Our Ref: ENV/08/3/8/14/6

**Ivanhoe Estate Redevelopment Concept – development application (SSD 8707)**

**ATTACHMENT 1 - TABLE OUTLINING ISSUES WITH REVISED CONCEPT DEVELOPMENT PROPOSAL/ RTS – SSD8707**

Figure 7 – Shrimptons Creek Indicative Plan

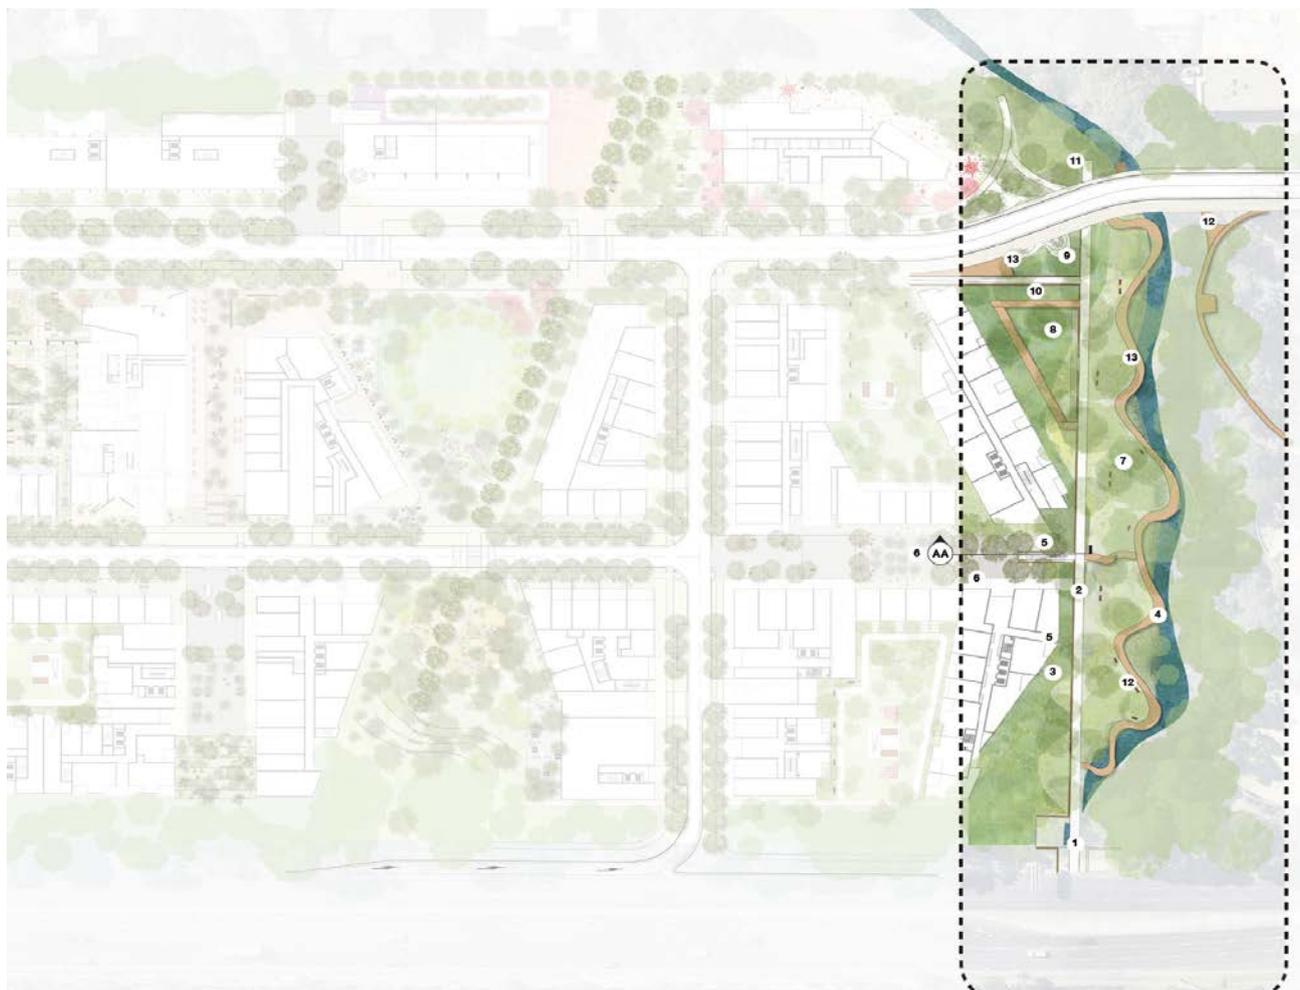
18	<p><b>Setback from the Creek</b></p> <p>The RDCP2014 requires a 20m setback from the side of the creek line plus a 10m buffer to protect the riparian corridor zone. However, the proposal provides only a 5m setback to the corridor.</p>	<p>Response to submission states that the building envelopes are setback 5 metres in accordance with the RDCP2014 requirements for setbacks from parks. Future detailed applications for buildings within these envelopes would incorporate the applicable building separation distances.</p>	<p>City of Ryde seeks that the setback along the creek be increased to 10m from the edge of 20m wide riparian zone. This will provide a better interface with the park in light of the increased building height along the creek, minimization of overshadowing and improved amenity within the park.</p>

Figure 8 – Deep Soil Landscaping

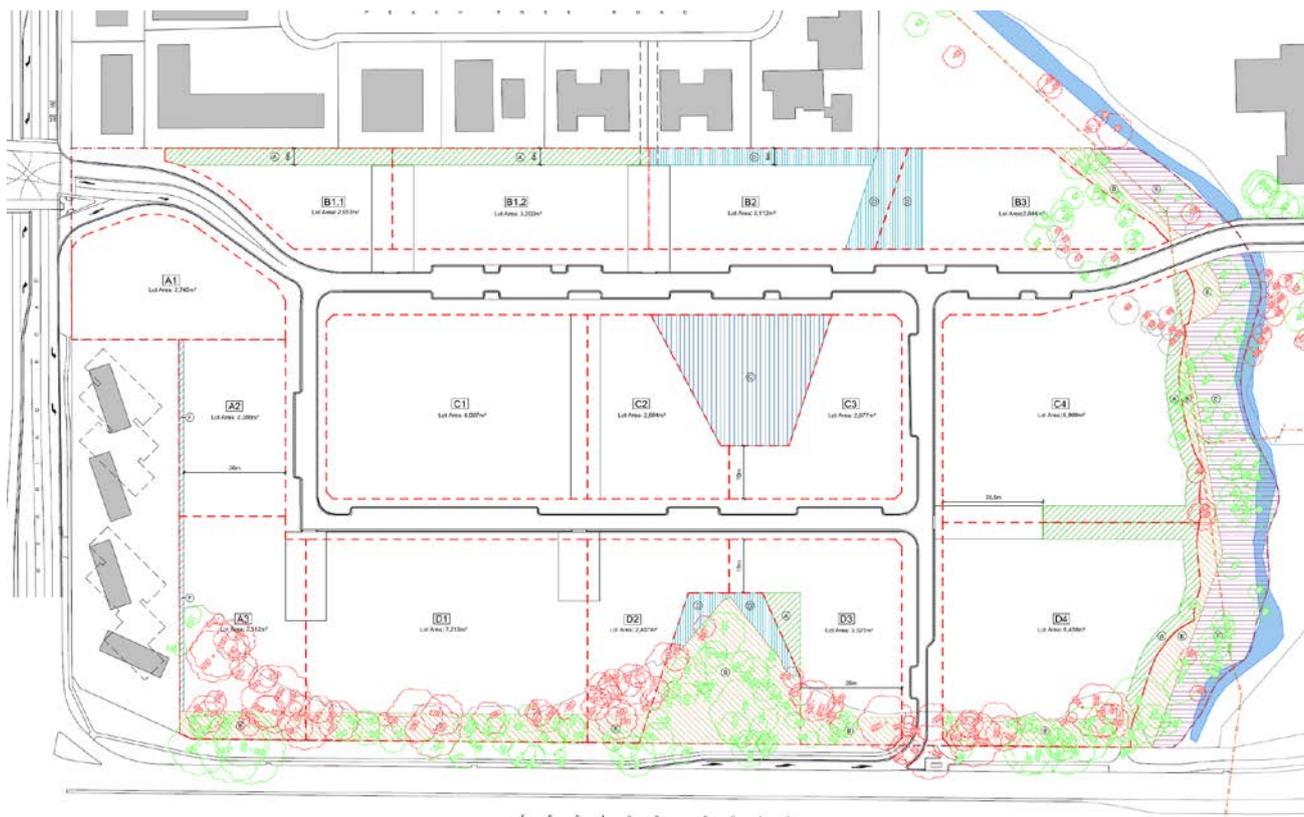
- Insufficient setback from the Riparian Corridor;
- Insufficient deep soil zone
- Non-compliance with RDCP in regards to the road width and width of the bridge;
- Lack of drop-off pick up zones;
- Lack of adequate open space and community facilities;
- Exceedance of the floor space ratio;
- Overdevelopment of the site.

- Boundary Setback
- DCP Street Setback
- Park Setback
- 2m additional green setback

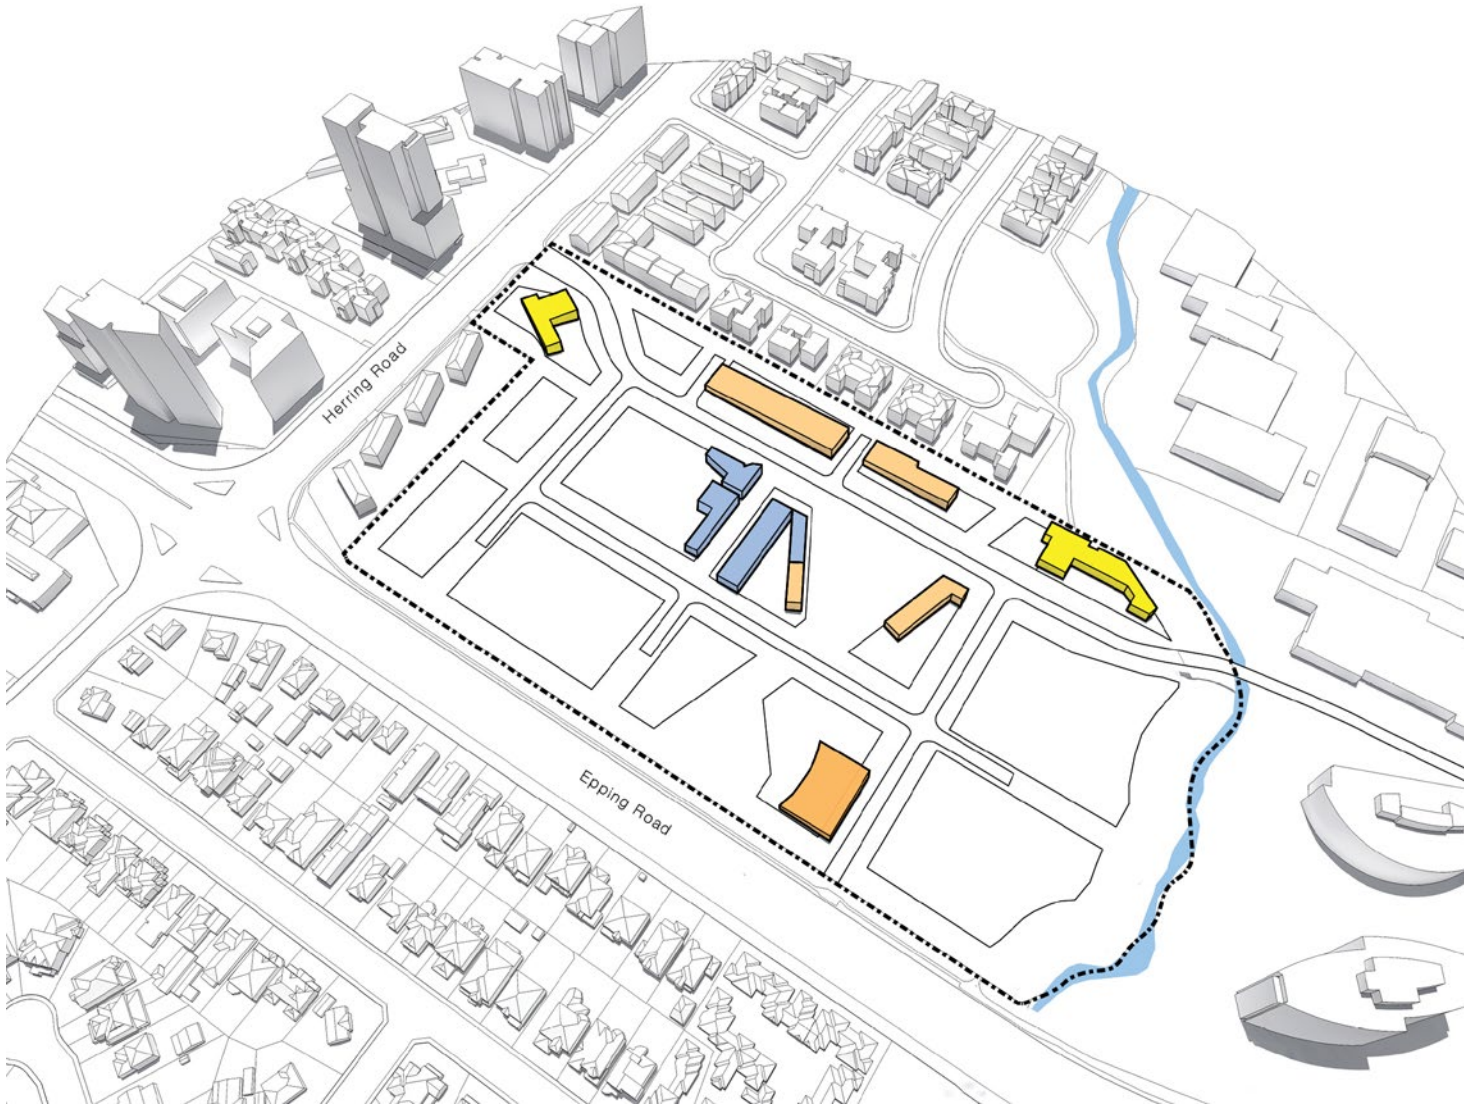
NUM	ISSUES PREVIOUSLY RAISED By COUNCIL (23/5/2018)	REVIEW OF REVISED PROPOSAL & APPLICANTS RESPONSE TO ISSUES	OUTSTANDING MATTERS WITH REGARD TO THE REVISED CONCEPT PROPOSAL: COUNCIL OBJECTION MAINTAINED AS PER MATTERS BELOW
		<p>C4, D1 and D4 will receive little sunlight in mid-winter.</p> <p>It is more effective to improve solar access to these locations by reducing building lengths to no more than 40m and increasing physical building separation to create wider corridors for solar penetration through the site.</p>	<p>locations by reducing building lengths to no more than 40m and increasing physical building separation to create wider corridors for solar penetration through the site;</p> <ul style="list-style-type: none"> <li>• Building depth for apartment buildings to be no more than 18m for improved solar amenity internally and externally;</li> <li>• Space between buildings facing Epping Road must be increased to open up additional area to allow sunlight penetration to the vegetation corridor along Epping Rd.</li> <li>• Building and basement setback along Epping Road be increased for the reasons discussed above.</li> </ul>
